# CITY OF ALBUQUERQUE

June 20, 2017

Bryan Knuckles, Dialysis Clinic Inc., bryank@wrnewman.com  
Site: DCI Southwest Mesa, 8217 Central Ave. SW  
Copy: rbuschman@wrnewman.com

**Re: Drainage Ordinance (14-5-2-1) Violations for Erosion and Sediment Control and Cement Pollution**

sheet no.
C5.00

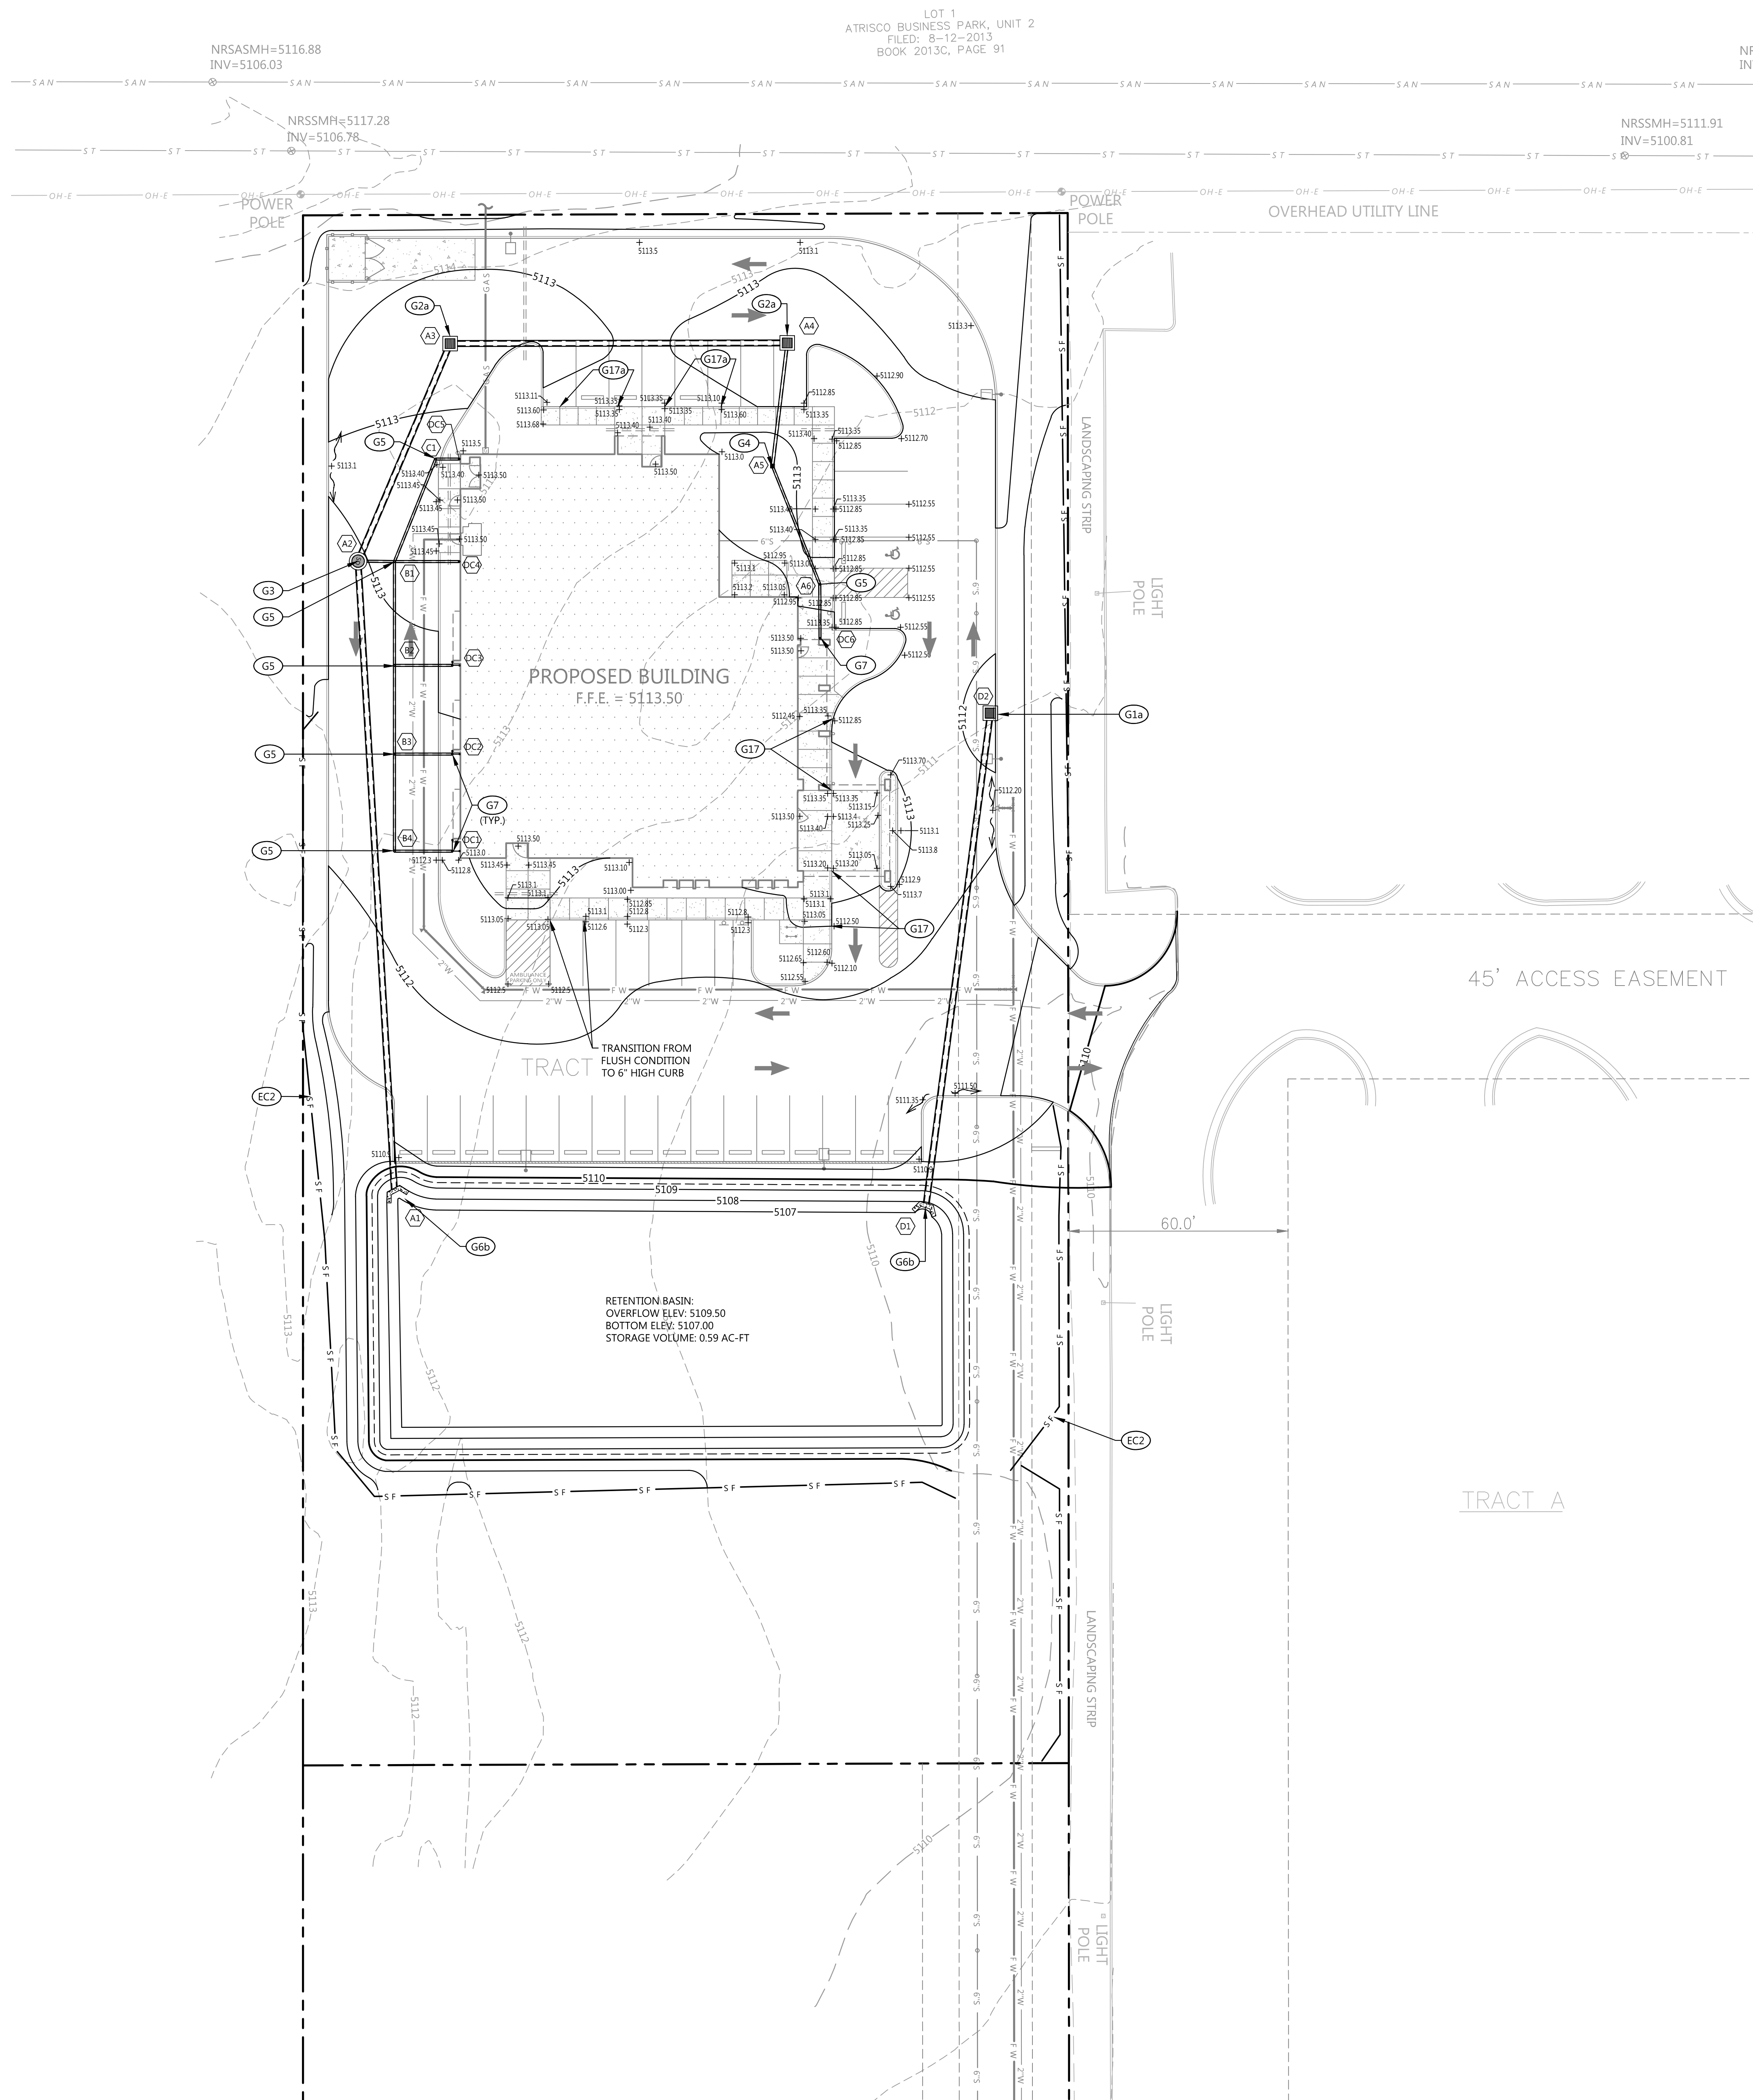
1. Two instances of cement pollution.
2. Track-out pad requires maintenance.

1. Remove instances of cement pollution.
2. Perform maintenance on track-out pad.
